Fire Marshal Division

Re: Steven Naylor Malone
1720 Chicora Dr.

Application Number FMFW2009-0005

The application for the outdoor public display of fireworks has been reviewed and approved as submitted. The public display **shall be in accordance with the NC Fire Prevention Code and NFPA 1123.**

Required Distance 280 FT Harnett GIS

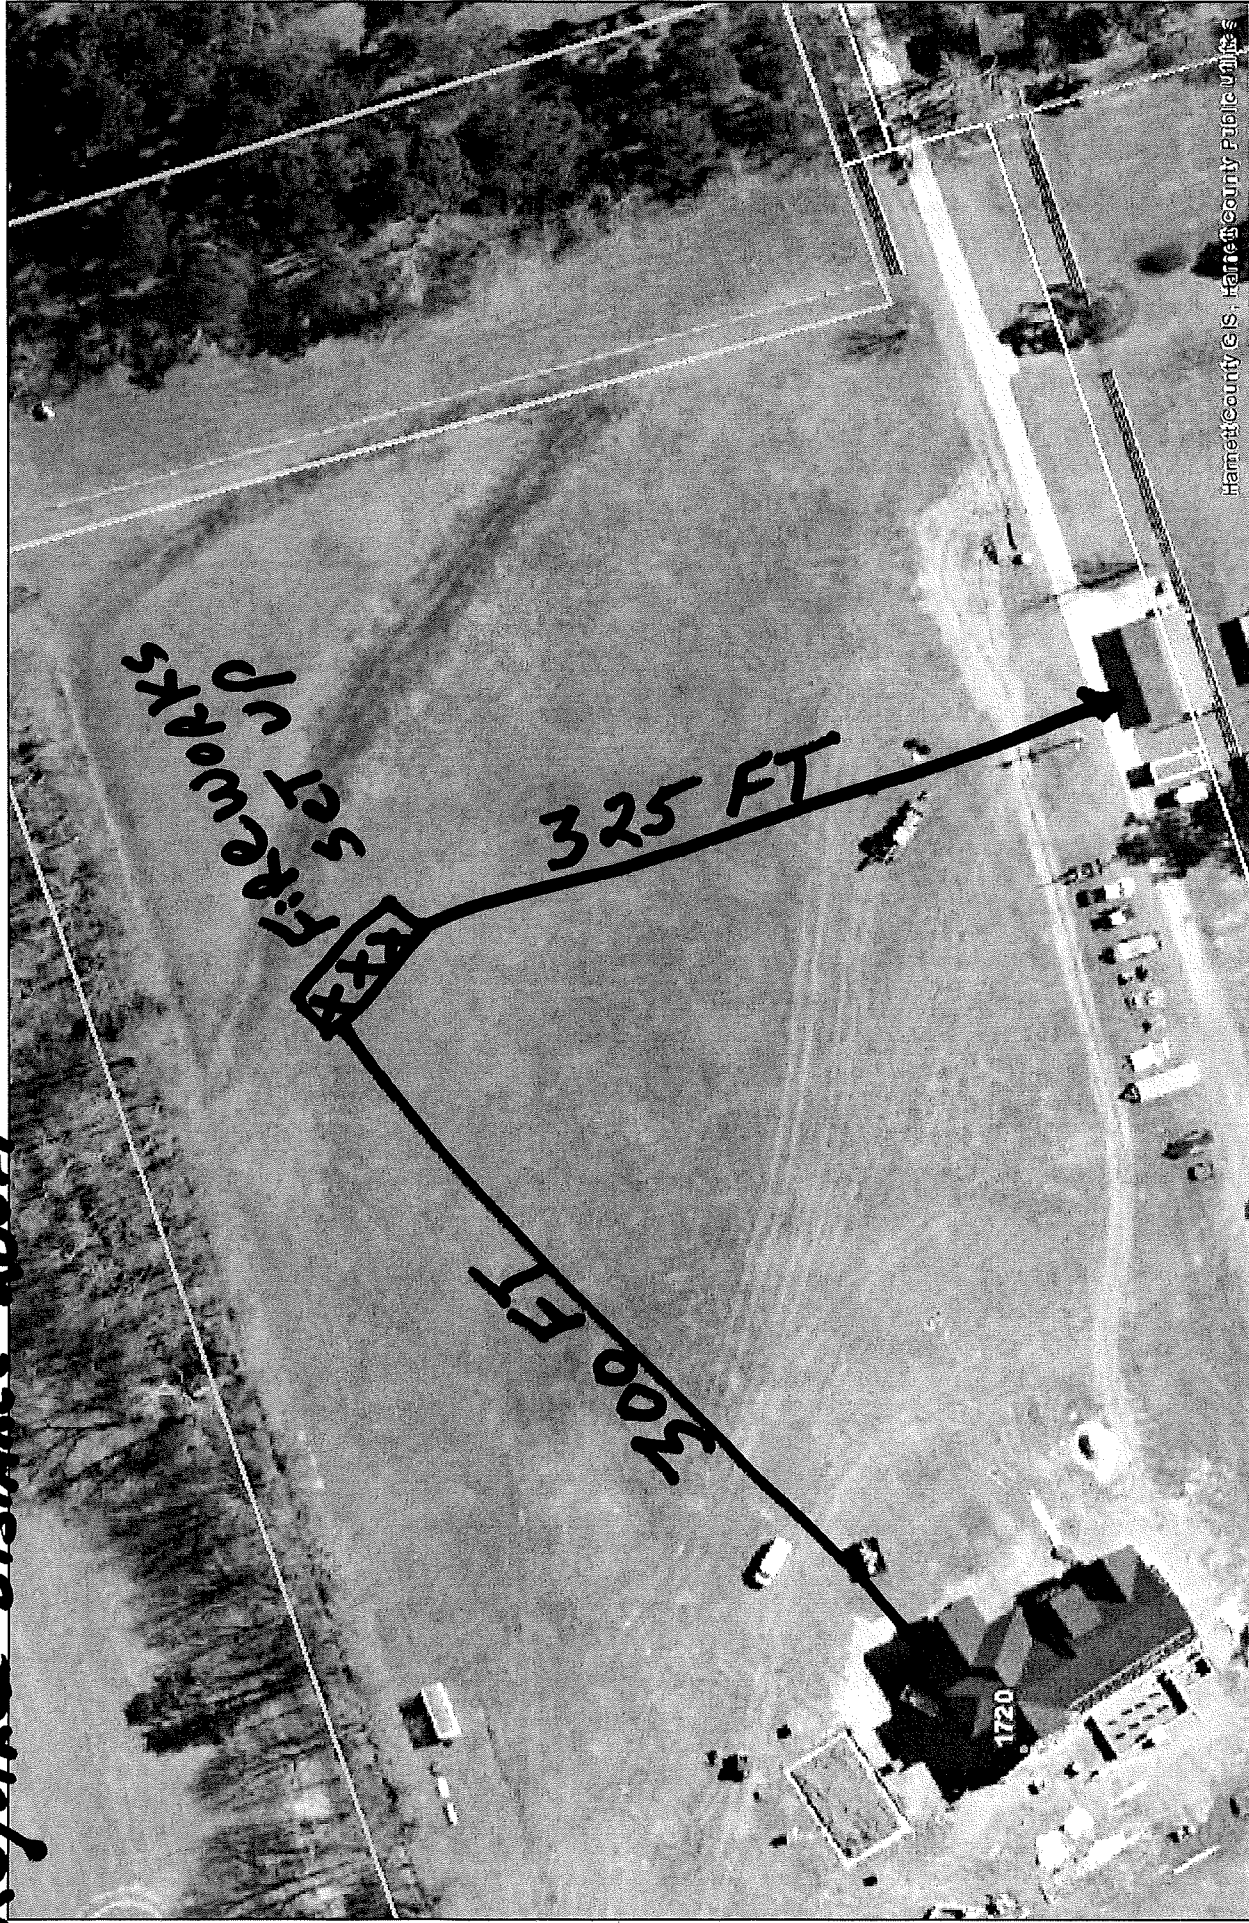
- **Distance**
 - At least 70 feet for diameter inch of shell must be provided between the shoot site and the public (4" largest mortar = 280 feet)
